**CITY OF MERCER ISLAND**

July 11, 2018

RE: Review Comments for File No. CAO17-010 – Hou Critical Areas Determination  
4825 E Mercer Way, Mercer Island, WA 98040; King County Tax Parcel # 216200-0070

Revisions	By	Date
Date	7-21-2017	
Scale	1"=20'	
Designed	AQ	
Drawn	MW	
Checked	OA	
Approved	ES	
Project	#1124B	
Sheet #	W11

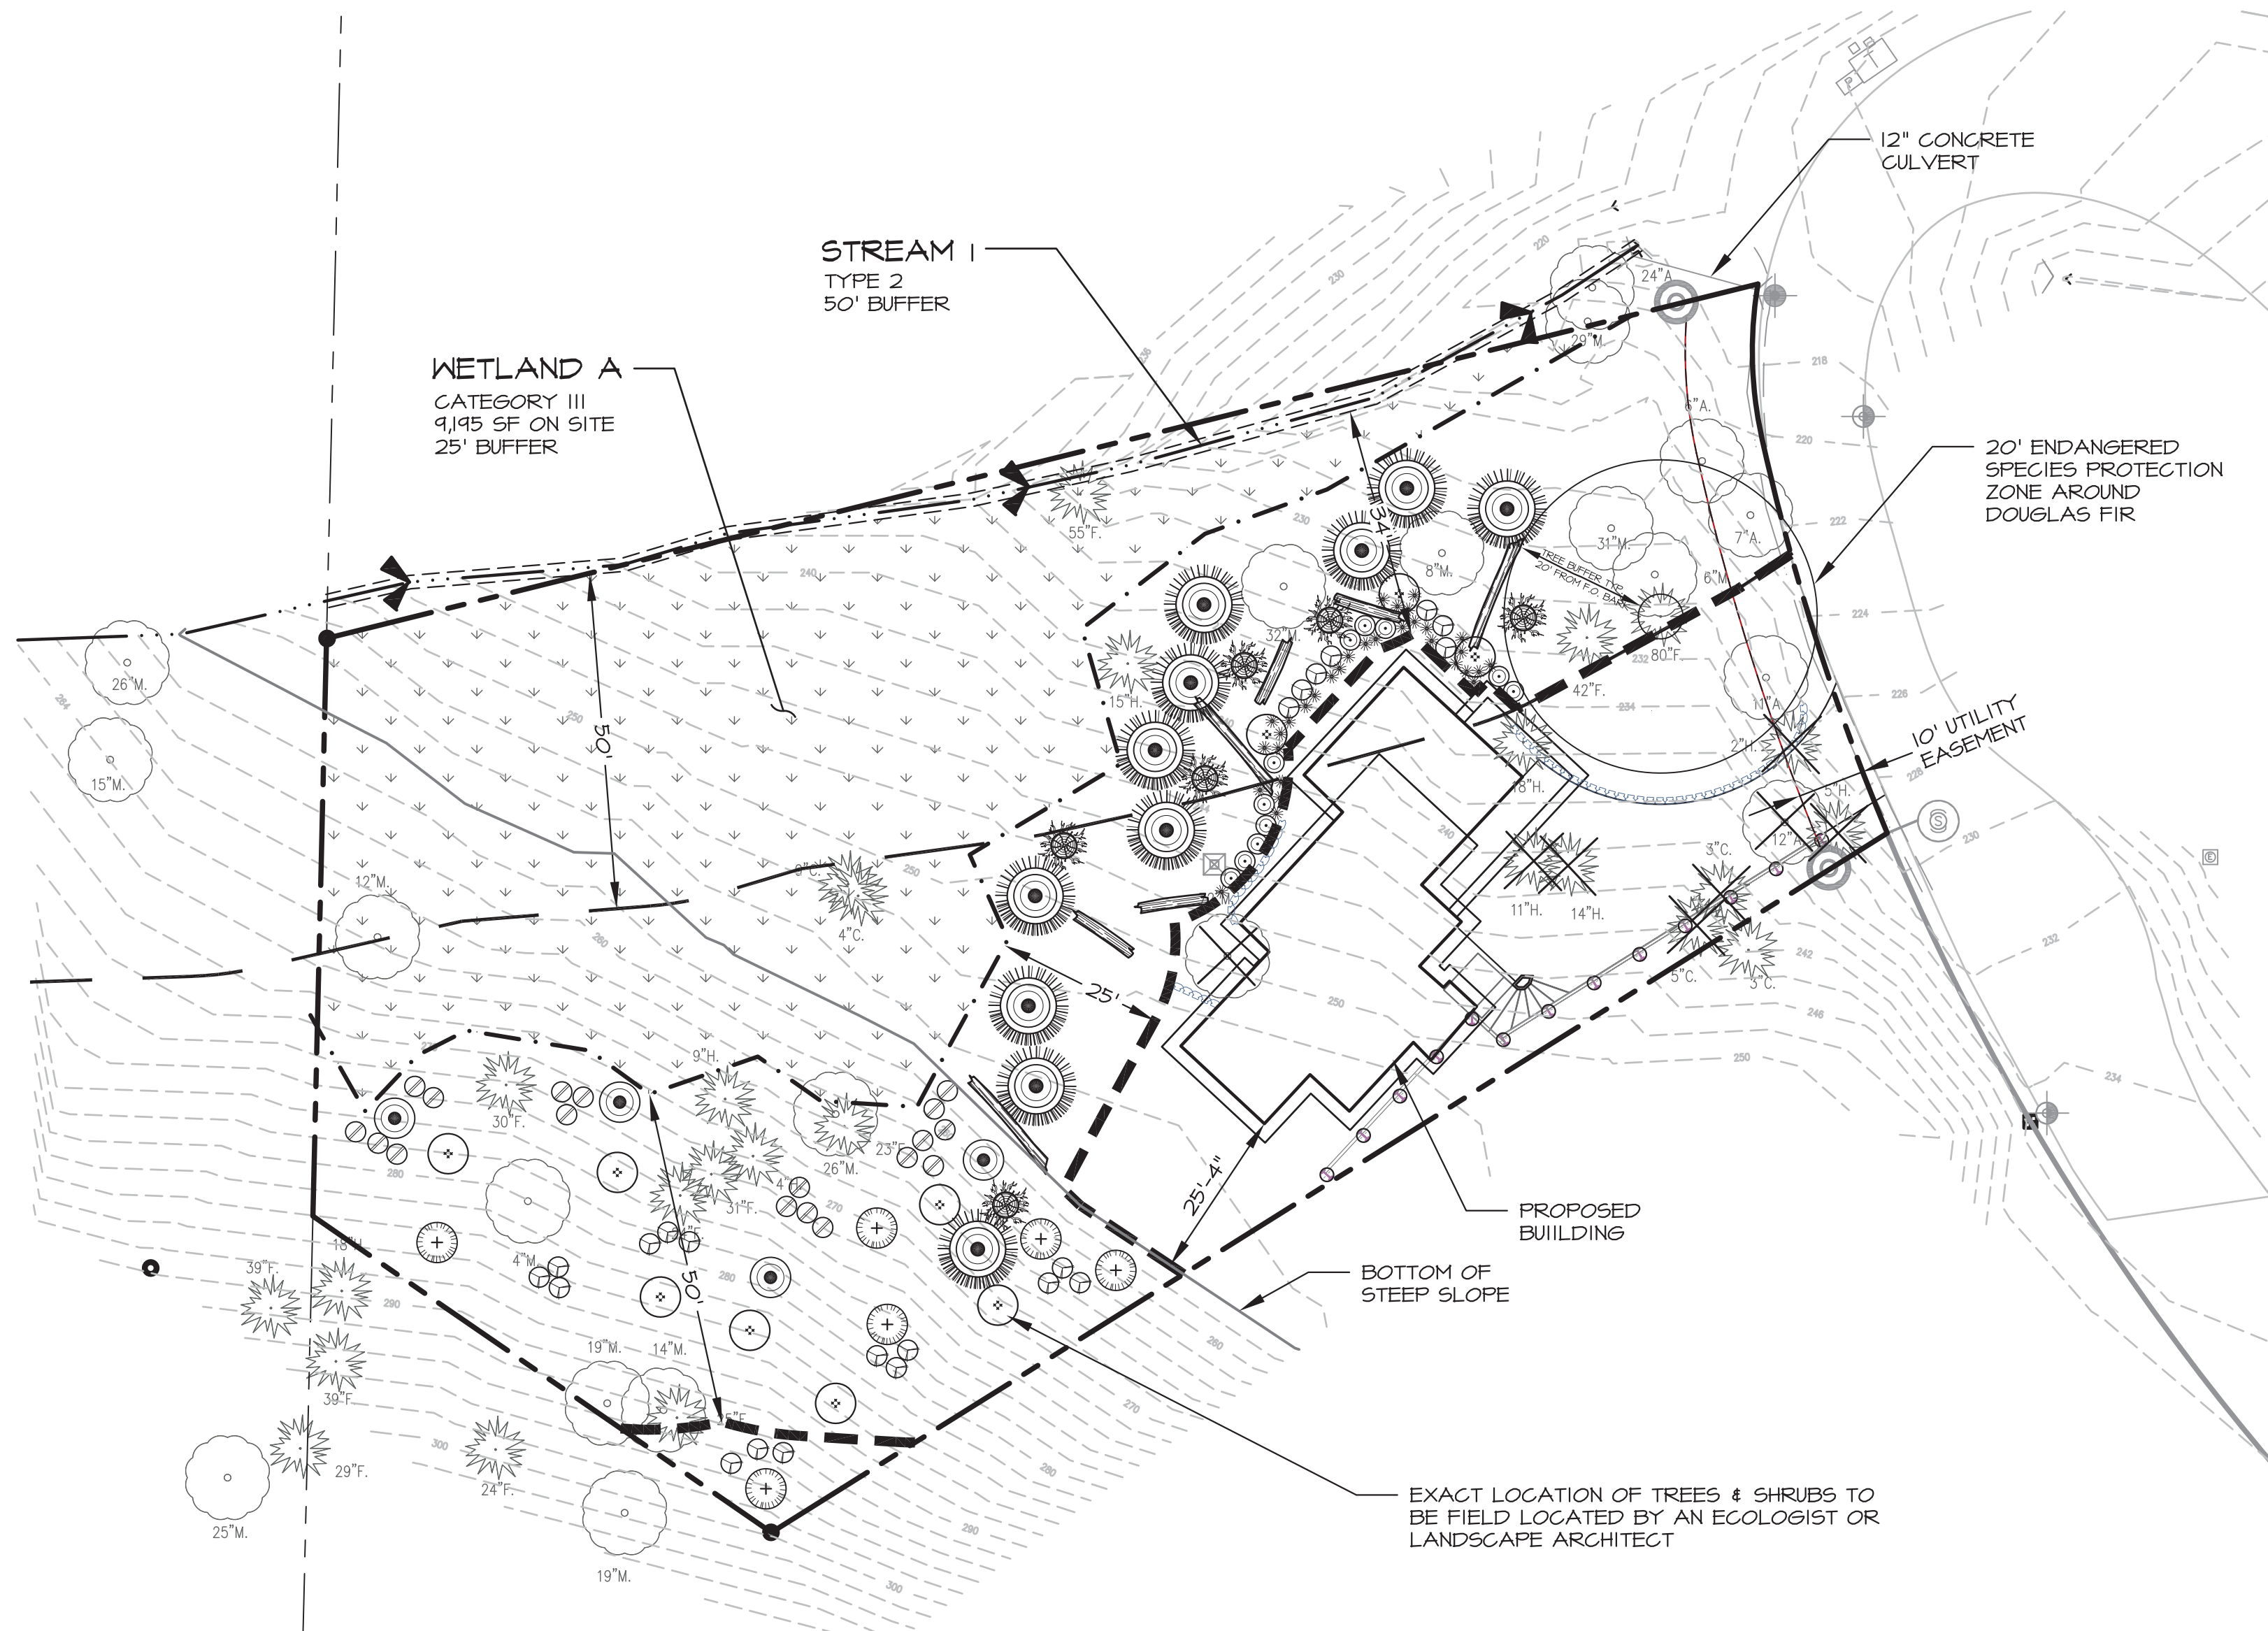
3. According to MICC 19.07.070.b(3)(c) the total area contained in the averaged buffers cannot be decreased below that total area that would be provided if the maximum width were not averaged. The legend on Sheet W1.1 of the mitigation plan indicates that area of stream buffer reduction is 354 square feet and the area of stream buffer replacement is 333 square feet. Since the area of stream buffer reduction is more than that area of buffer replacement the mitigation plan is not in compliance with code requirements. In addition, the stream buffer replacement area proposed is not contiguous with the stream itself and therefore

does not contribute to function and values. Instead, the area of stream buffer replacement is located within the buffer of Wetland A and likely provides benefits to the wetland's buffer. Please provide stream buffer replacement contiguous to the stream.

4. The proposed woody shrub plantings in the eastern portion of the buffer enhancement area for stream buffer reduction mitigation will be planted approximately 34 feet from Stream 1 at the southern edge of the buffer, bordering the proposed house. The placement of woody shrub plantings at this distance will not significantly contribute to improving stream functions. In addition, proposed plantings for the remaining portions of the buffer enhancement area are sparse and limited in number. ESA does not believe that the proposed buffer enhancement would provide adequate mitigation for impacts from buffer averaging, as these features would not significantly improve ecological functions of the stream.

6. The wetland and watercourse buffers shall not be reduced within the drip lines of trees 916 and 917 which provide habitat benefits (e.g. shading, organic inputs, etc.) to the wetland and watercourse. Please add the drip lines of these trees to the plan sheets.
